Your Ref :-AW/368/17/HH

5th March 2018

PROPOSED ALTERATIONS TO CREATE 'GRANNY ANNEXE' AT
44 CHRISTCHURCH CRESCENT WESTMEADS PO21 5SJ
SCALES AS SHOWN.....PLANS.....DRG NO 640 - 01B

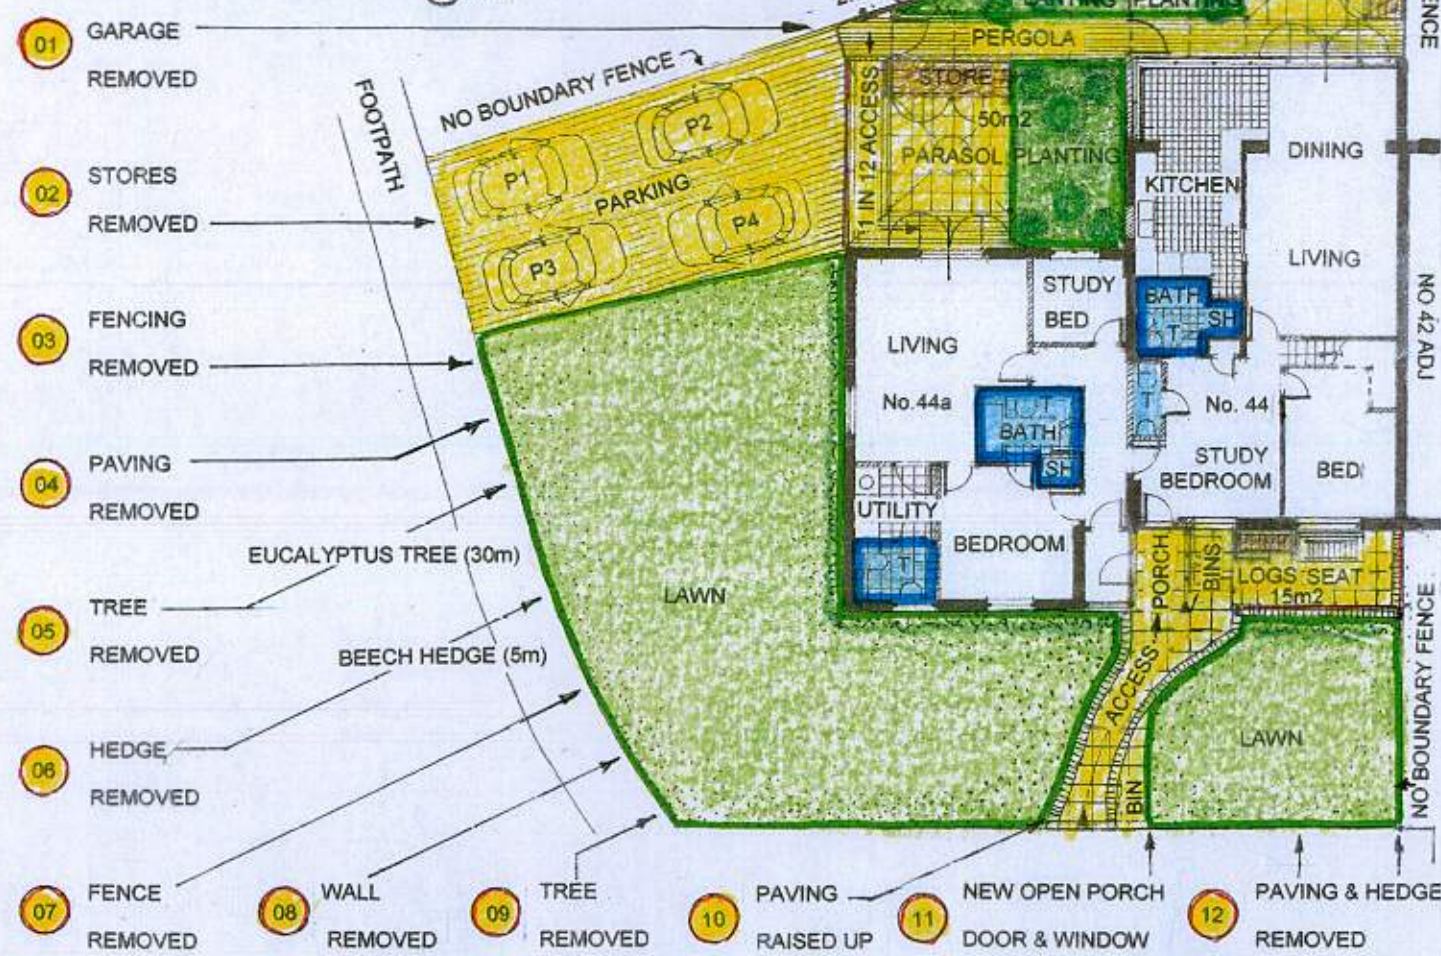
The proposed plans to create a Granny Annex & make 2 separate dwellings, with an over development of buildings using the garden space parking area and general layout.

This is out of character with other dwellings on this estate which have separate drives for each home. It would also be unsuitable for parking on the roadway as it is situated on a corner.

44 would become a terraced property sandwiched between 42 & 44a with very little garden and no driveway to park cars off the road.

It is also noted the intention to add a staircase to the loft into the now so called storage area (ex bedroom) . There appears to be no skylight on the original plans.
